## **Preliminary Report on Metrolink Route and its Potential Effect on the Cadenza Building**

**Waterman Moylan Consulting Engineers Limited**

**Client Name:** Irish Life Assurance plc.  
**Document Reference:** 18-020r.101  
**Project Number:** 18-020

Drawing No.	ML1-JAI-EIA-ROUT_XX-DR-Y-21149	Rev	P02
-------------	--------------------------------	-----	-----

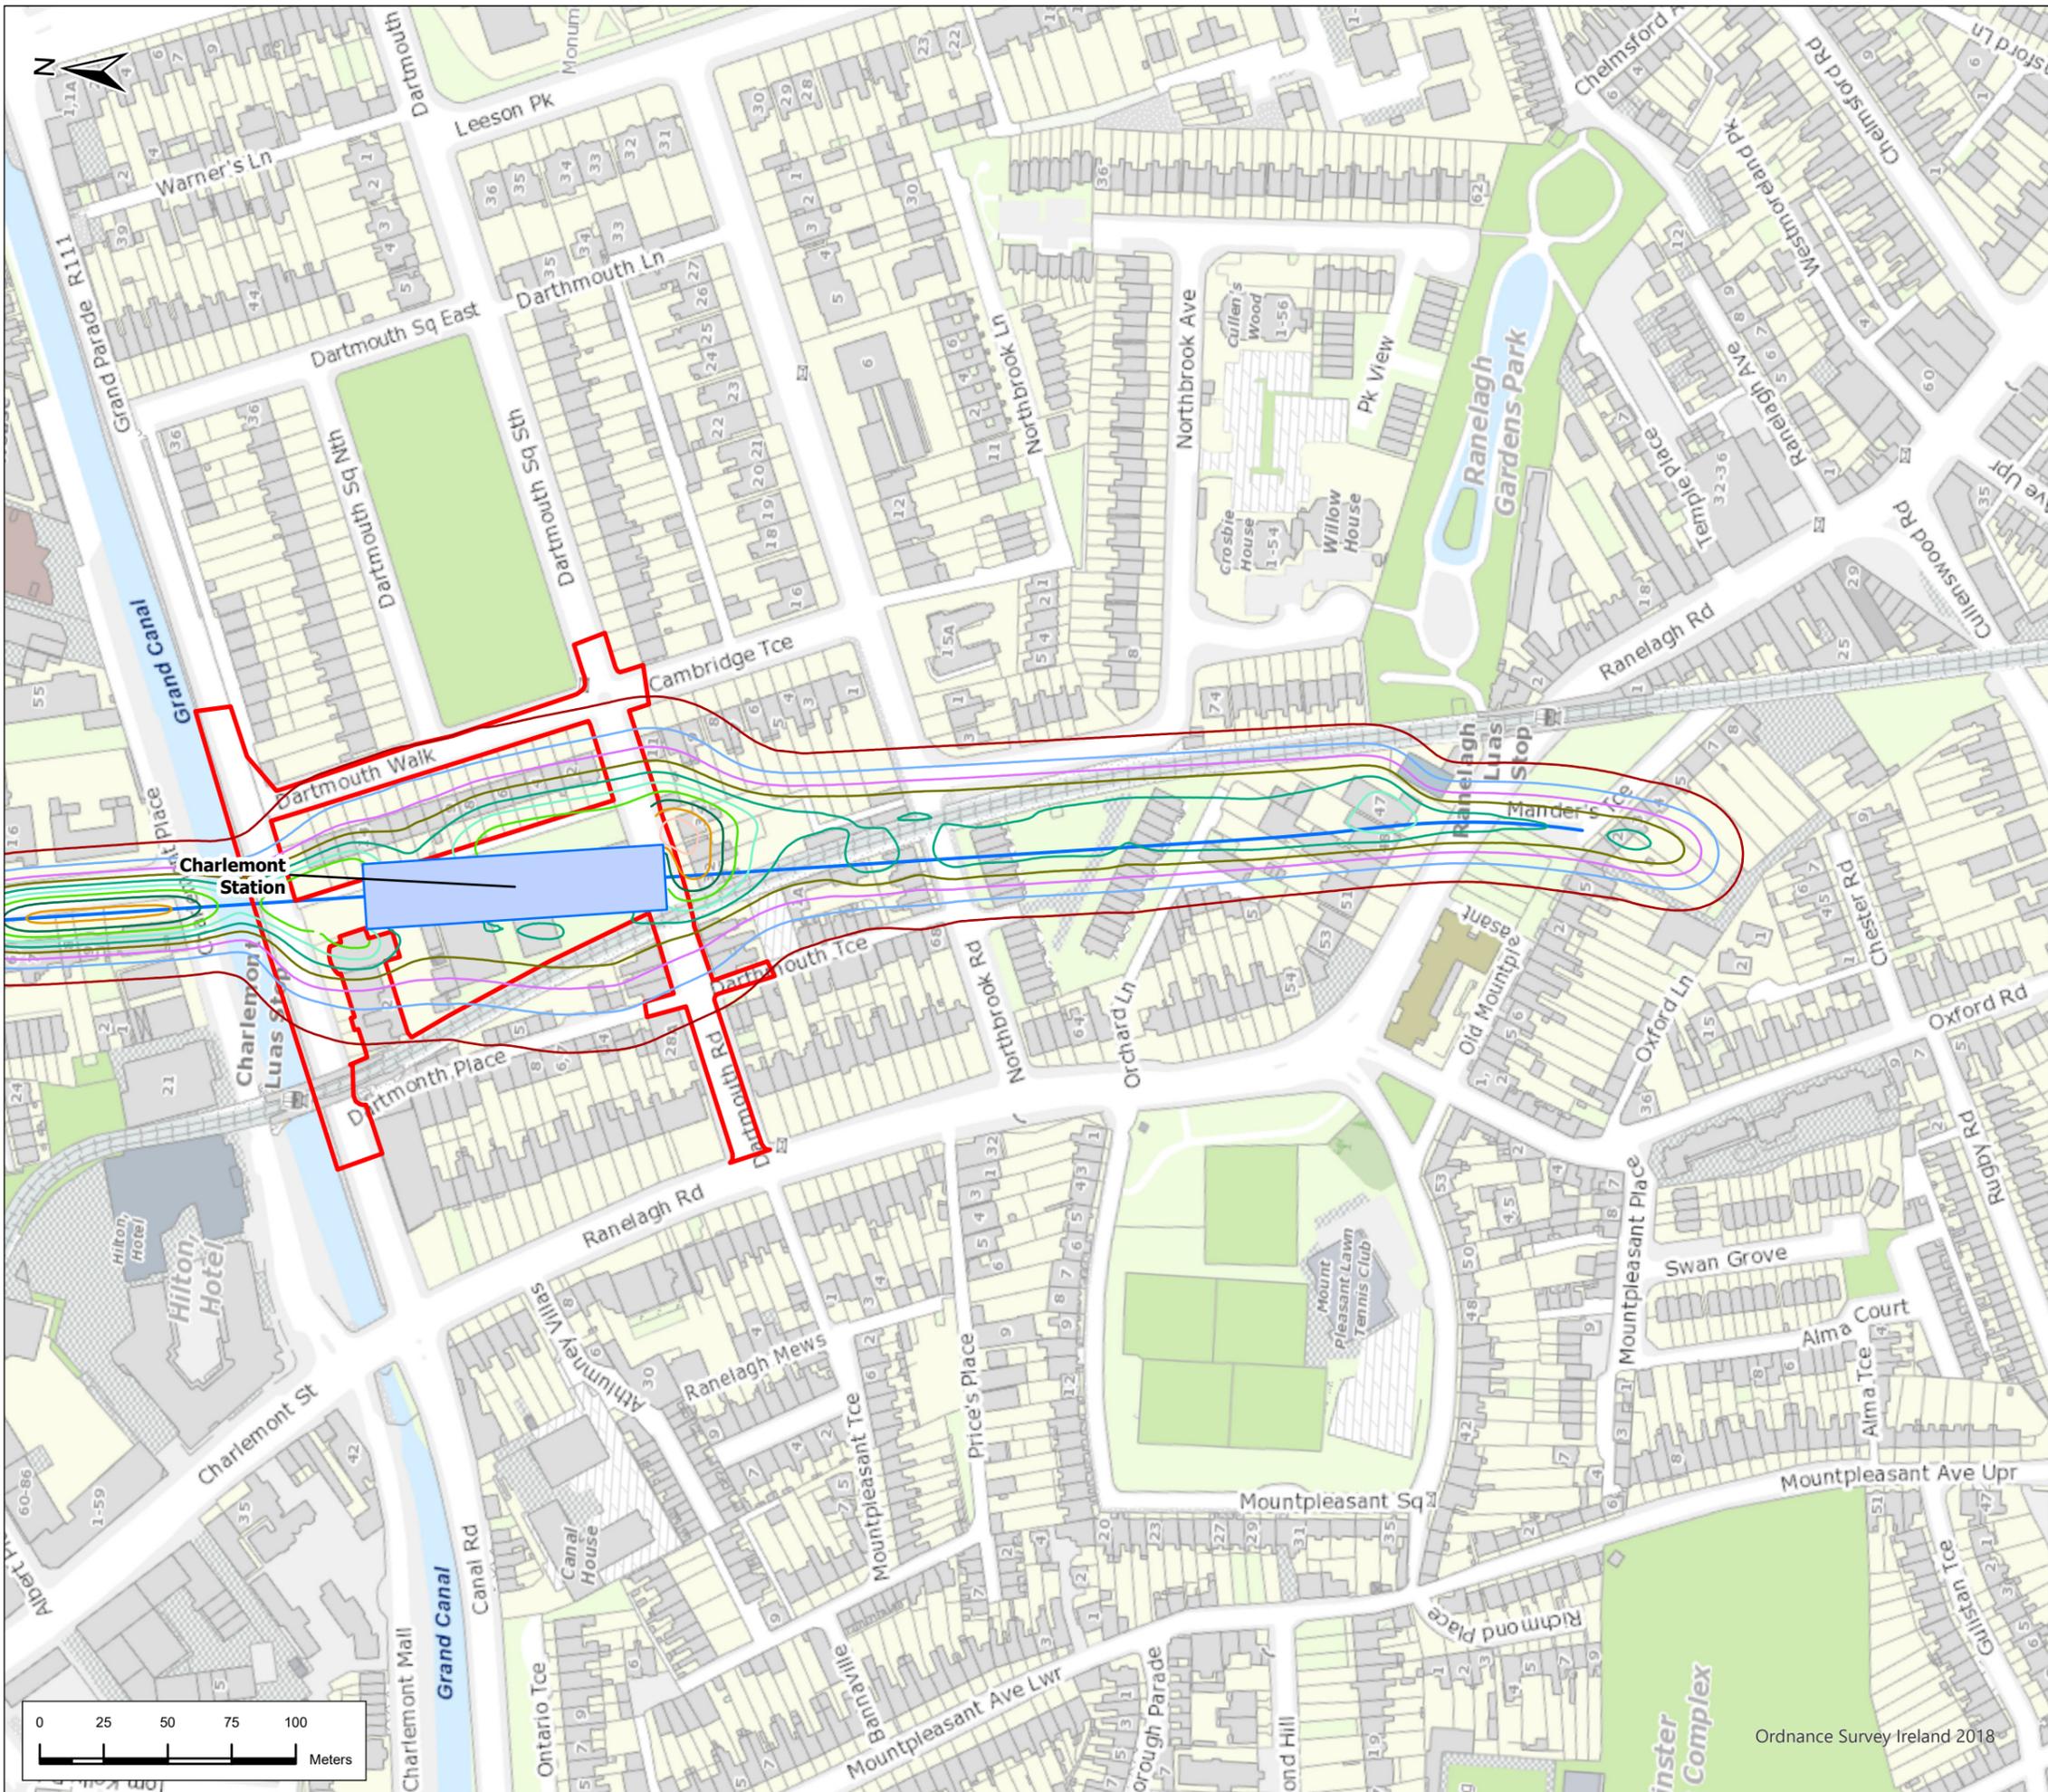
Jacob / IDOM drawing number ML1-JAI-EAI-ROUT\_XX-DR-Y-21146, revision P02 dated 23 February 2024 (which appears to supersede ML1-JAI-EAI-ROUT\_XX-DR-Y-21149 revision P02, which was included in Appendix C of the BDR), indicates the Jacob / IDOM engineers predict subsidence/settlement of up to 30mm under the footprint of the Cadenza Building. A copy of Jacob / IDOM, drawing number ML1-JAI-EAI-ROUT\_XX-DR-Y-21146 Rev P02, has been included in Appendix A of this Report for ease of reference.

The magnitude of the subsidence/settlement under the Cadenza Building is not uniform and varies from 0mm to 30mm. The maximum subsidence/settlement is experienced directly under one of the main stair cores, which provides stability to the building.

The settlement contours presented by Jacob / IDOM indicate that differential settlement/distortion of the Cadenza Building is going to occur, resulting in the following damage:

- The basement uses a Whitetank waterproofing system, which relies on the watertightness of the reinforced concrete basement floor slab and walls. Therefore, even minor cracking could lead to groundwater ingress;
- The internal reinforced concrete frame uses post-tensioned reinforced concrete floor slabs for large spans, which would be more sensitive to differential settlement than conventional RC slabs;
- The tunnel passes under one of the main structural cores for the building, and this incorporates a complex transfer structure at the first-floor level to accommodate a shift in the position of the core for the upper floors of the building;

- The building has a modern steel and glass façade, which would be more sensitive to distortion due to differential settlement along the perimeter secant pile wall than a masonry or blockwork structure.

The Cadenza Building can not accommodate movement of this magnitude without damage to the structure, waterproofing and facades being caused.
